BOHANNAN-HUSTON INC.

Re: Phase III--Final Developed Conditions Report of the Restudy of AMDS  
 Volume II.

This letter addresses City of Albuquerque comments on the previous Phase II Developed Conditions Report, AMDS Volume II delivered to Bohannon-Huston, Inc. in a July 16, 1987 meeting. Since most of these comments were presented to Bohannon-Huston, Inc. orally, the oral comments will be repeated below with the Bohannon-Huston, Inc. response following the comment.

N-15

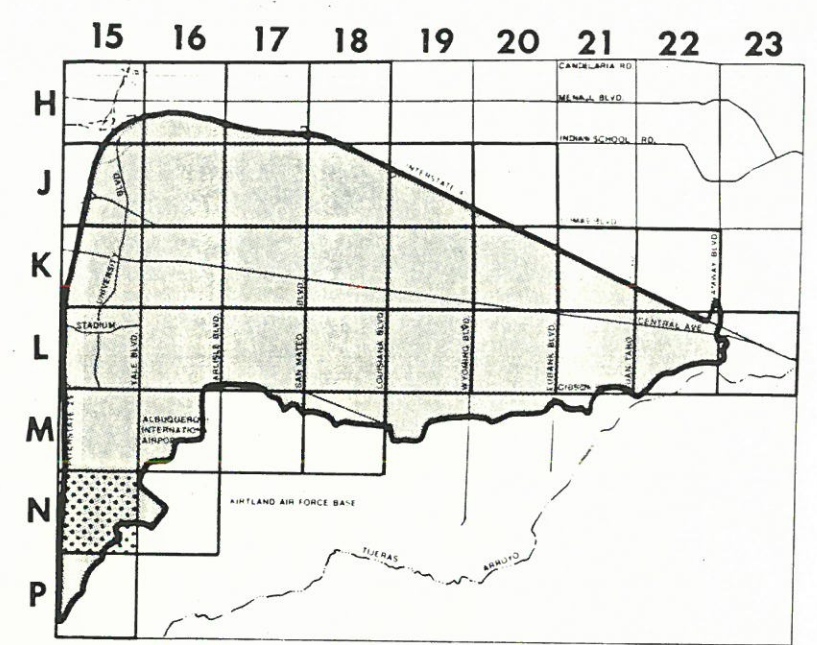
Comment: Sheet N-15. Modify flooding to reflect new 60" pipe extension.

Response: Completed.
